**SSD 7317 - MODIFICATION 12 - RESPONSE TO SUBMISSIONS
AUSTRALIAN TECHNOLOGY PARK, EVELEIGH**

This Response to Submissions letter has been prepared by Ethos Urban on behalf of Mirvac Projects Pty Ltd (Mircac) to address submissions received during the notification period of the Section 4.55(1A) Modification 12 (MOD 12) to State Significant Development 7317 (SSD 7317) which relates to the development of a commercial campus at the Australian Technology Park, Eveleigh.

Figure 2 The proposed modification to Indigenous Garden
 Source: Aspect Studios

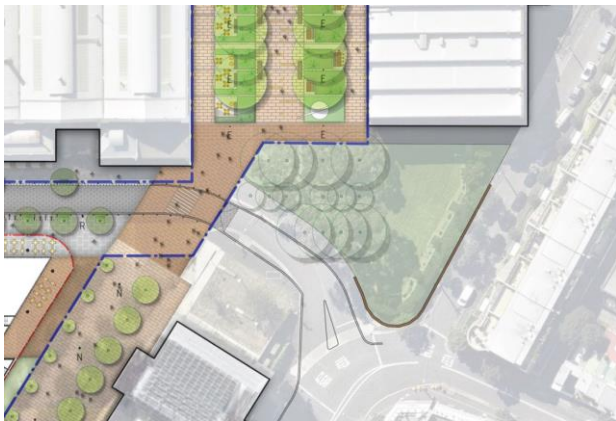
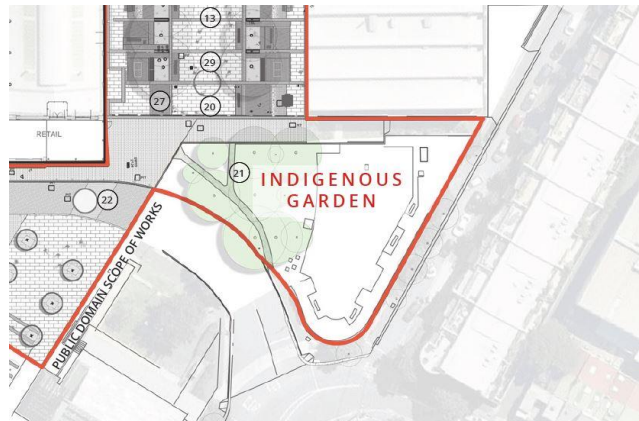
It is unclear whether the new Indigenous Garden will form part of the landscaping and public domain works to be completed under Public Domain Area 1 or Public Domain Area 2?

It is recommended that the works to the new Indigenous Garden are specifically included into Public Domain Area 2. As per condition B53D, works to Public Domain Area 2 are to be completed prior to the issue of the first OC for Building 2. This timing is consistent with delivery of the Stage 2 Heritage Interpretation Plan. If the subject modification is to be approved, the Department are recommended to require the proponent to formally amend the Public Domain Staging Plan to incorporate the new Indigenous Garden for the avoidance of doubt.

The City objects to the proponent's request that 'The detailed design of the Indigenous Garden will be confirmed within the Stage 2 Heritage Interpretation Plan for the Public Domain and the detailed construction level drawings will be provided to the PCA as part of the relevant construction certificate documentation'.

- i. *Given the heritage significance of the Indigenous Garden and its prominent location at the north eastern entry of the precinct, the City request that the Department require consultation with the City of Sydney on the detailed design. Specialist landscape knowledge is required to critically assess the design presented by Aspect Studios and identify any matters that need to be addressed to ensure the longevity of the scheme.*

- ii. *It is the City's preference that the detailed design is provided to the City prior to the determination of the subject modification application. The level of detail expected is akin to the level of detail that was provided to satisfy Public Domain Areas 1 and 2. Aspect Studios are very familiar with the level of detail required by the City.*

- iii. *If the detail is not ready yet pending further design resolution or due to ongoing heritage investigations, an amendment to the wording of the approved condition B53A should be made by the Department. The amended wording should be phrased so that it is clear that the Indigenous Garden is now included in the area defined as Public Domain Area 2, and the Staging Plan that forms the package of information for Public Domain Area 2 is amended to reflect the addition of the Indigenous Garden. By incorporating the Indigenous Garden into the condition, the same level of detail that was required for the rest of the landscaping and public domain areas in the precinct will also be provided for the Indigenous Garden and be subject to consultation with the city. Further, the above change will ensure that the Indigenous Garden is captured by the requirements of the rest of the associated conditions i.e. B53C and B53D.*

The Indigenous Garden is to be a key Heritage Interpretation element in this location and will sit outside of the scope of works for Public Domain Areas 1 and 2 and as such can be considered to be part of Area 3 as shown in the Staging Diagram included at **Attachment B**.

On this basis, Mirvac consider that the Indigenous Garden is to form Public Domain Area 3, as outlined in the revised Public Domain staging plan at **Attachment B**. It will also will be included within the Stage 2 Heritage Interpretation Plan and as such will be completed prior to the issue of the last Occupation Certification for Building 2.

The revised Landscape Masterplan prepared by Aspect Studios outlines the location of the Indigenous Garden. However, the design presented on the Masterplan is indicative only. Ultimately, the design is not landscape architect led, it is community led.

In order to provide further indicative detail, a concept plan for the Indigenous Garden is included at **Attachment C**. As set out in the modification application, the detail design will be confirmed within the Stage 2 Heritage Interpretation Plan. Due to the nature of the Garden, it is not considered necessary for the Council to critically assess the detailed design to ensure the longevity of the scheme. The space is intended to be an organic, free flowing space that supports Aboriginal cultural engagement, education and heritage interpretation. Yerrabingin and the community will be responsible for its longevity along with Mirvac who will oversee and ensure the ongoing up keep and quality of the Garden.

The amendment of Condition B53A to include the Indigenous Garden (as Council has recommended) is not accepted. In Mirvac's opinion, if consultation is undertaken with the Council in the manner they are requesting, the focus of the community led design will be compromised resulting in a design that is more focused on the standard City of Sydney technical specifications rather than its original intent and connection with the historical stories and community engagement.

Figure 4 The proposed wellness and skate/scooter park
 Source: Aspect Studios

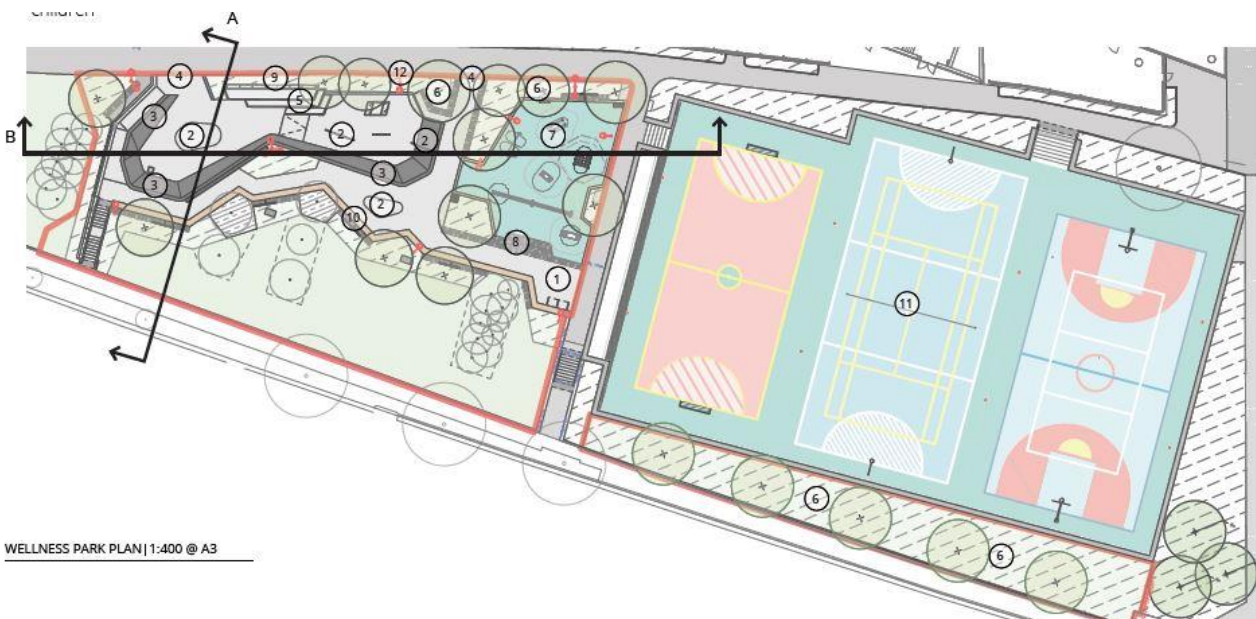
The concept design for the Wellness Precinct appears generally acceptable however, it is unclear what the grey hatch lines mean within the grassed area to the south of the scooter/skate park. It should be clarified what is on soil and what is on slab.

Given that this area is likely to be regularly frequented by children, there is no indication what security gates or the like are within or around the scooter/skate park. There is a steep fall towards Henderson Road. How is access into and out of this area of the precinct managed to ensure small children will not wander into the surrounding streets.

It is noted that there are shade trees around the perimeter of the scooter/skate park however, the scooter/skate elements are quite open and not protected from the sun. Are additional shade structures or the like required in the mounds etc. given that small children will use it for potentially prolonged periods? This is a consideration akin to play areas at child care centres or the like.

These areas are intended to be planted garden beds to provide landscaping features for the area.

There are no security fences or gates proposed as part of the design of the scooter park. The design includes a range of ledge and bench seat spaces that will act as an informal fence between the scooter park and Henderson Road, while ensuring carers and parents have visibility across the entire space. The intention is for an open and inviting space unrestricted by fencing and gates to welcome the community into the Park. This is consistent with the approach for the entire ATP public domain, which provides open and unrestricted access to all of the play areas.

The proposed scooter park and gym equipment area extends to approximately 725m² in area and is not a child care centre space. Any shade structure would require further redesign and may introduce support poles into the skate elements themselves, creating a safety hazard for users of the space.

Notwithstanding this, some shade will be provided by Building 1 and the proposed trees that surround the scooter/skate park, which include Yellow Gum, Brush Box, Golden Robinia, Water Gum and Magnolia species. These tree species have been selected for their height and canopy cover, which range from 7m (Magnolia) to 15m (Brush Box) in height, with canopy widths of 5m (Yellow Gum) to 10m (Brush Box).

Additional shade structures are not proposed to be provided.

EVELEIGH GREEN LANDSCAPE PLAN | 1:400 @ A3

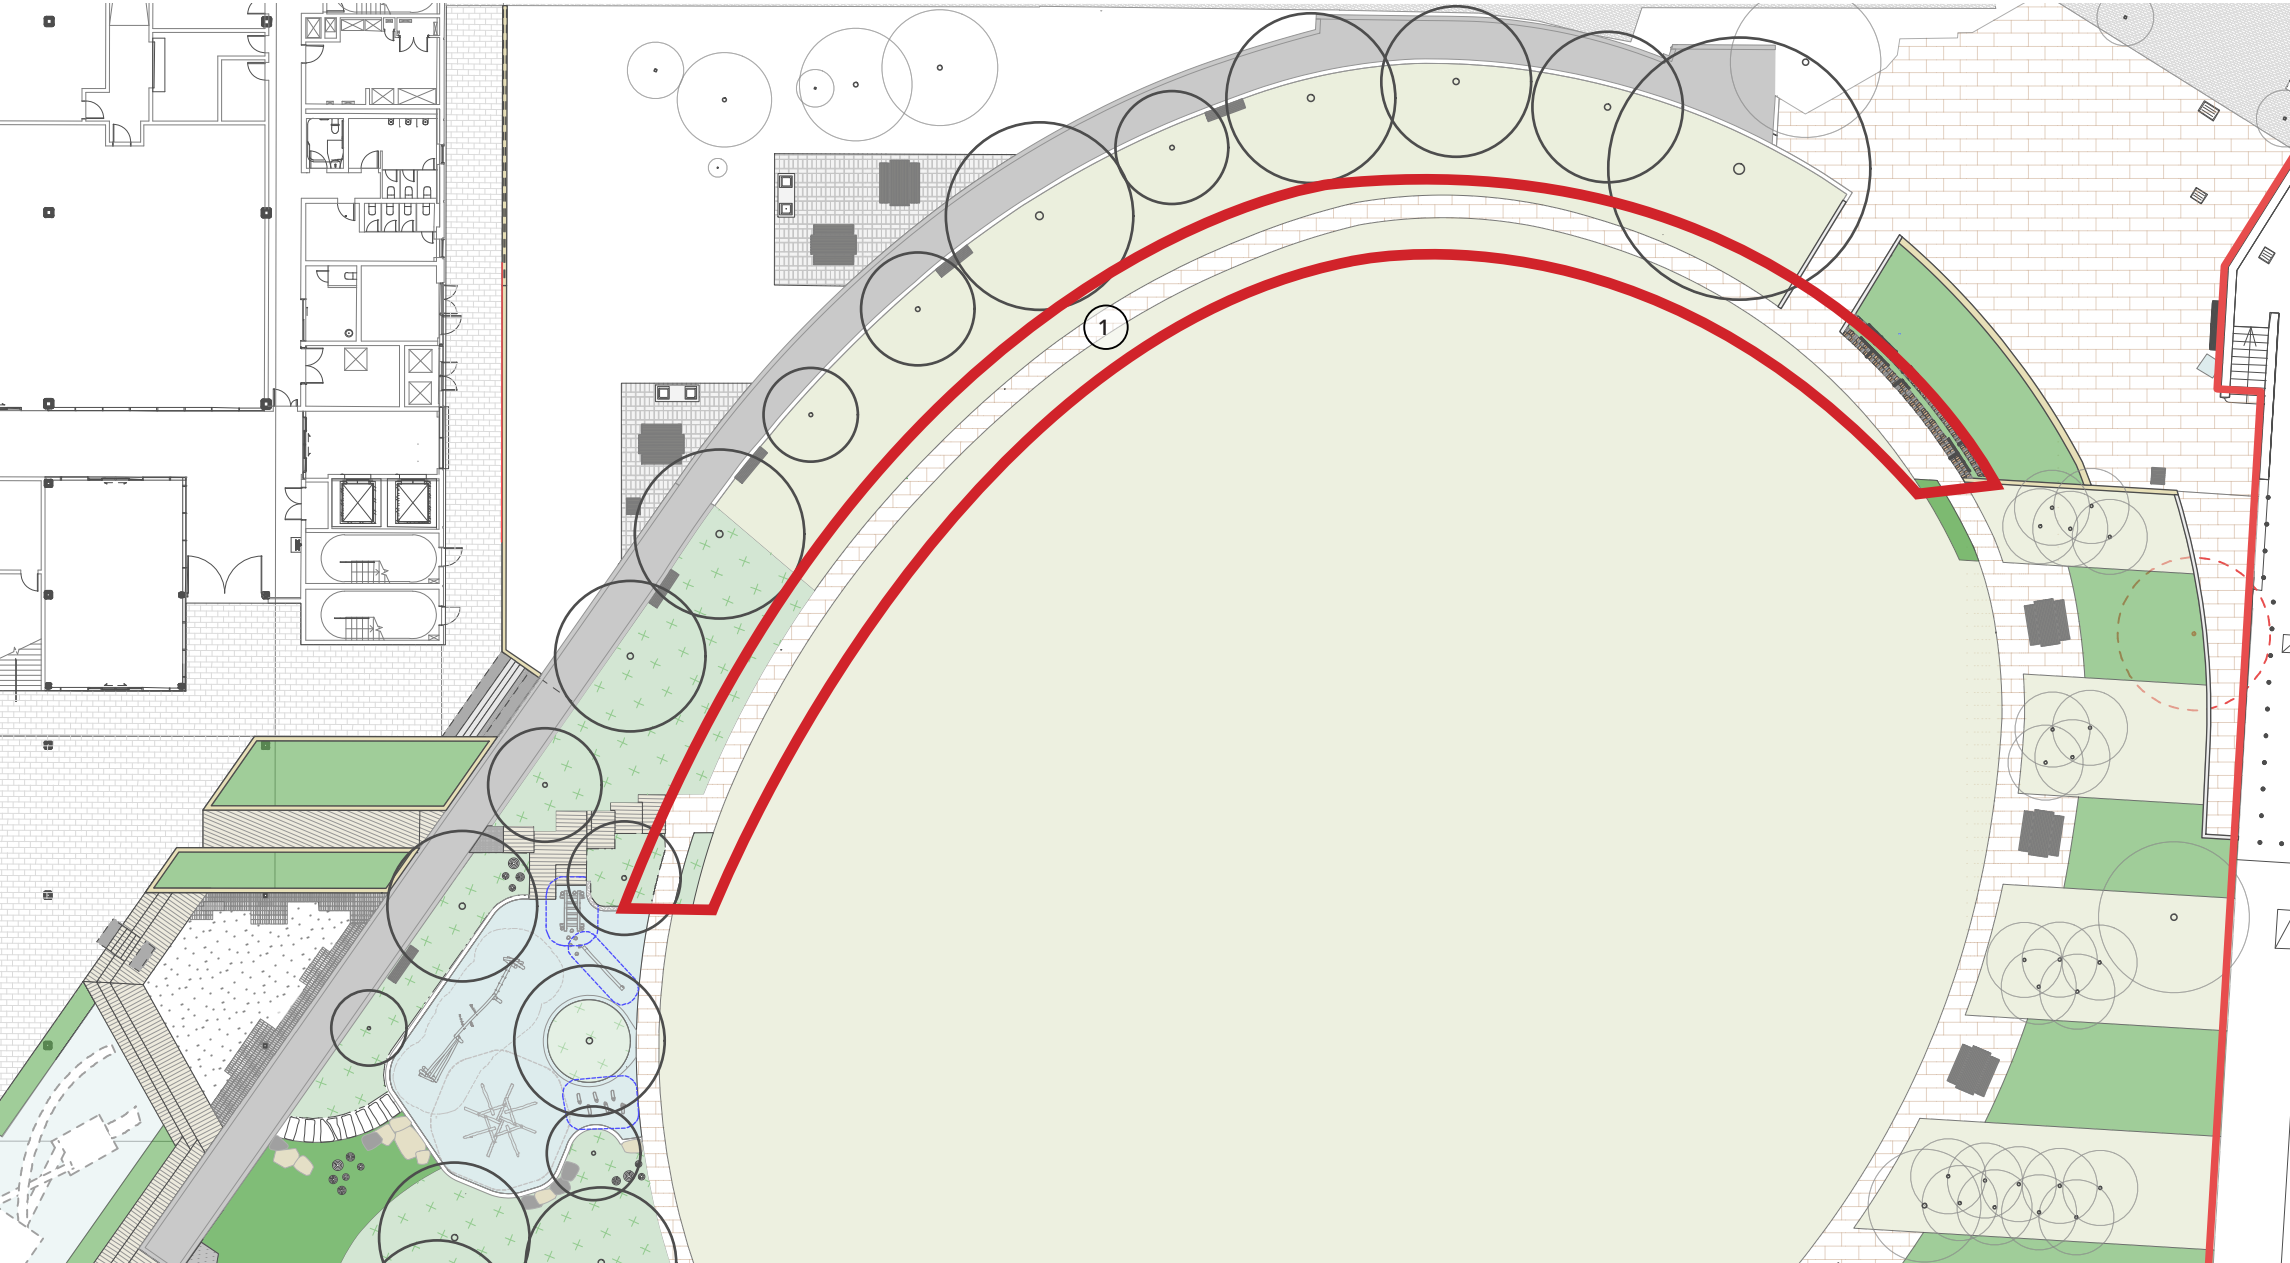
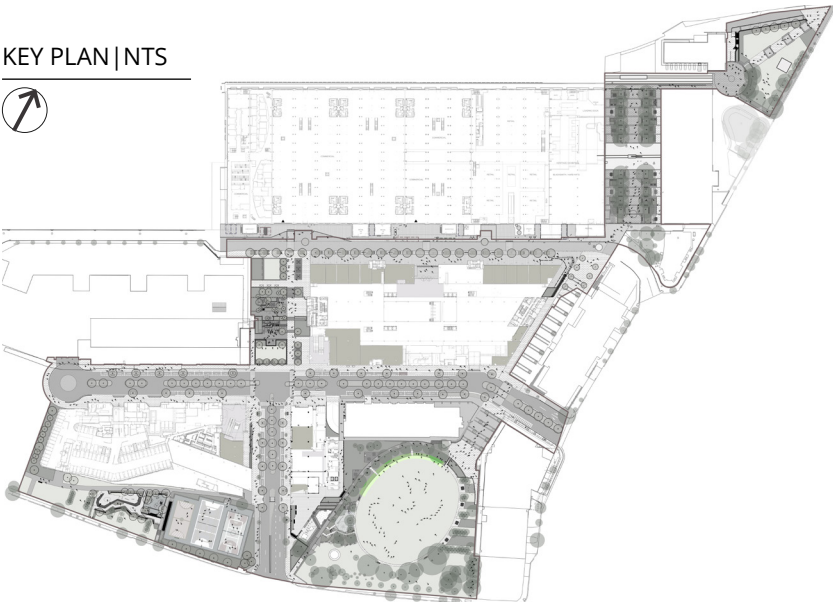
The concept proposal appears to be acceptable. However, as per above, the City objects to the proponents request for the more detailed drawings of Eveleigh Green to be submitted to the PCA for final approval. Eveleigh Green is within Public Domain Area 1. Any detailed drawings including future amendments to the approved PD Area 1 package should either be assessed via the subject application with sufficient detail provided for assessment, or re-satisfy the condition via the consultation process with the City and the Heritage Council as required by the wording of Condition B53A for resubmission to the Secretary.

It is noted that Council considers the change to Eveleigh Green to be acceptable. The change to Eveleigh Green is extremely minor, resulting in negligible changes to the pathway to avoid impacts on the established trees. This insignificant change which has no consequential impact on the overall public domain design, clearly demonstrates why proposed Condition B53E should be approved.
